From: Breezie Allwright <Breezie.Allwright@arun.gov.uk>
Sent: 23 January 2026 11:53
To: Planning.Responses <Planning.Responses@arun.gov.uk>
Subject: Fw: R/215/25/HH

From: [REDACTED]
Sent: 23 January 2026 10:01
To: Breezie Allwright <Breezie.Allwright@arun.gov.uk>
Subject: Re: R/215/25/HH

Drawing:  
**Plans and elevations as proposed**

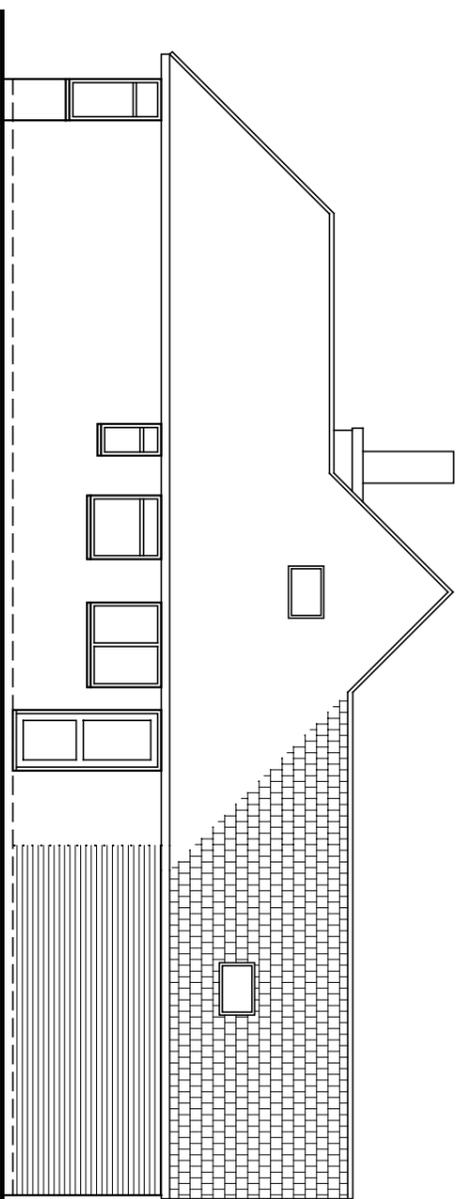
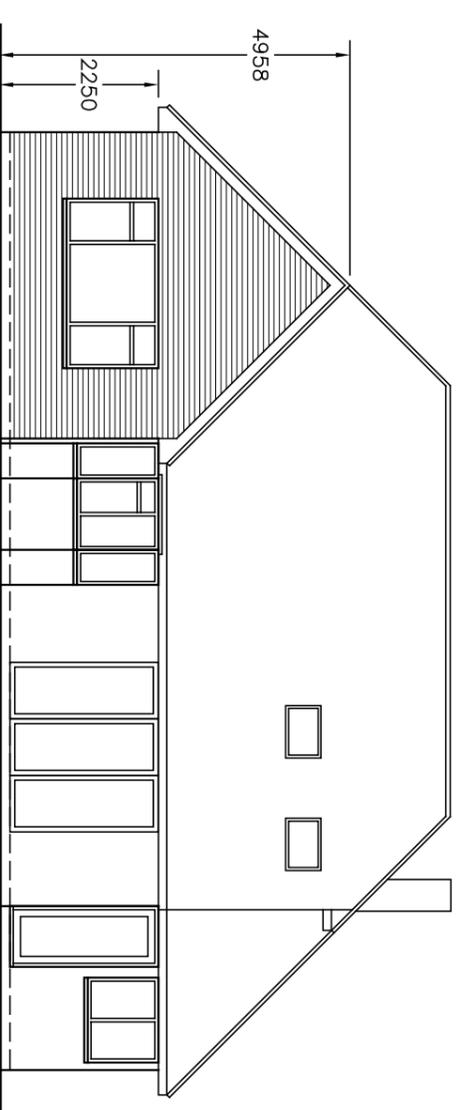
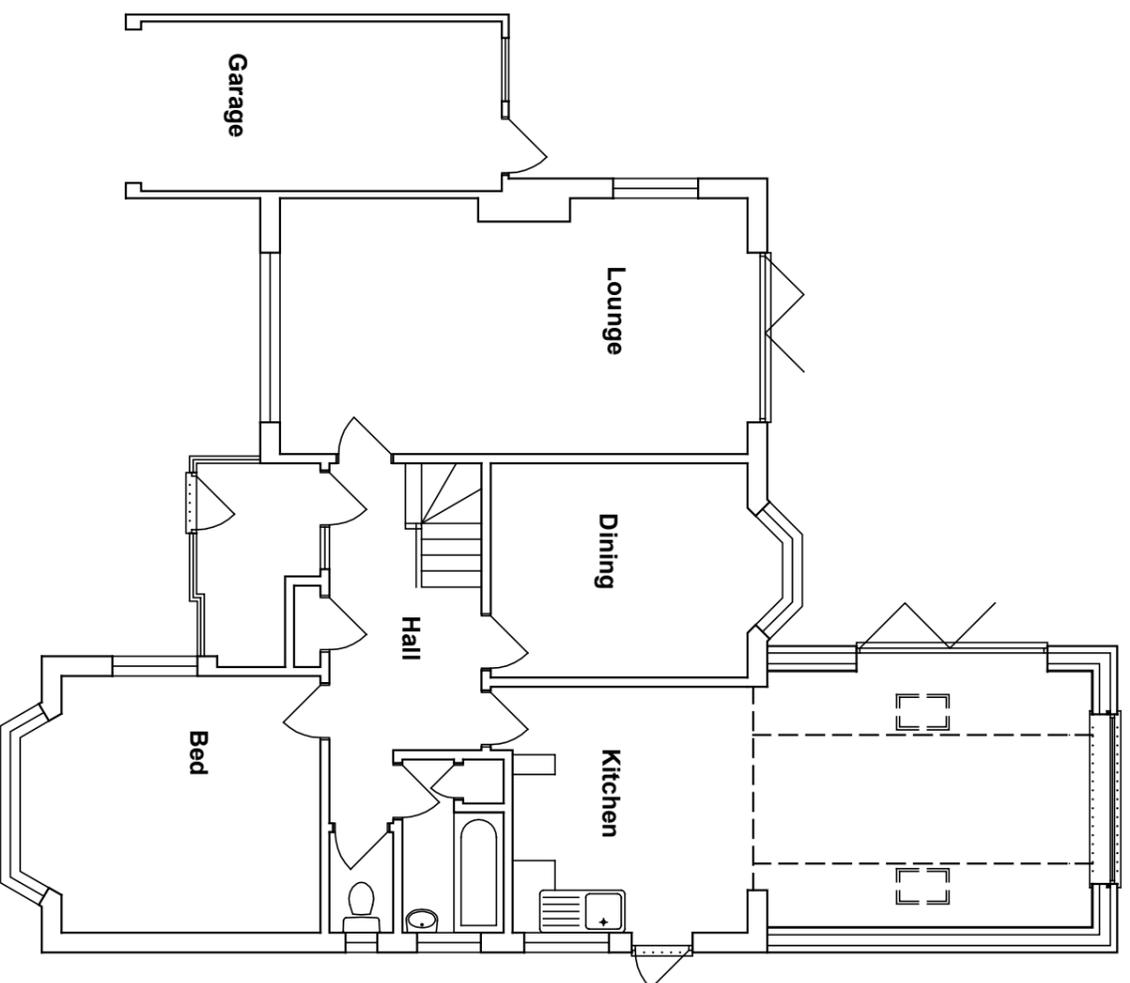
Proposed plans will leave "21 ft of brick wall and gutter", running along my south border view, in my direct view from my home, my south border outlook would be unsightly over shadowing overbearing, intrusive unsightly

21 ft of wall on south facing border i fear will

my south border where light comes from is where thompsons plan to build ,wall and gutter will be high enough to make this occur
